Rezoning Transportation Analysis

Petition Number: 2020-046

General Location Identifier: Tax ID 20103128

Date	Description
04-21-20	First Review
05-20-20	Second Review (FO)

Rezoning Site Plan

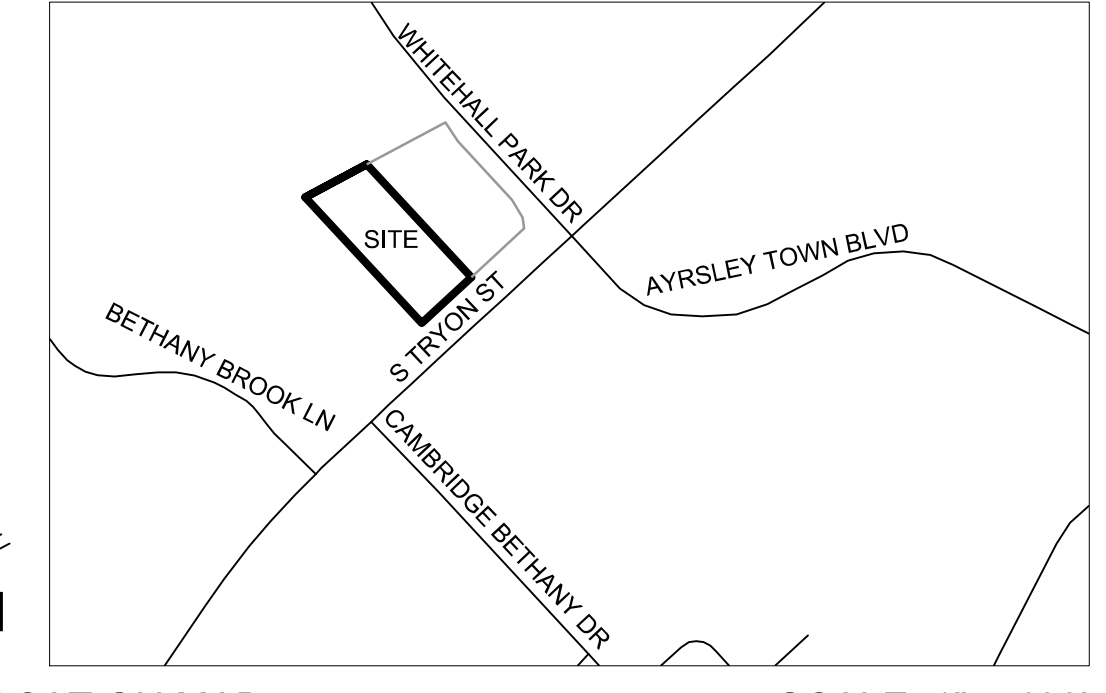
- ~~3. The petitioner should revise the site plan and conditional note(s) to preserve the existing driveway as right out only. Per NCDOT, a right in/right out driveway will affect the functionality of the intersection. Please provide CDOT with any other correspondence that the petitioner has had with NCDOT, since plans to convert this access to right in/right out were already submitted to the city for permitting review within Accela: LDC-2019-00062 - Leon Whitehall.~~

- ~~4. In reference to the Urban Street Design Guidelines (USDG), CDOT recommends the petitioner to revise the site plan and conditional note(s) to decrease the Tryon right out only radius for a SU-30 vehicle only, using Condition D of Appendix C of the USDG.~~
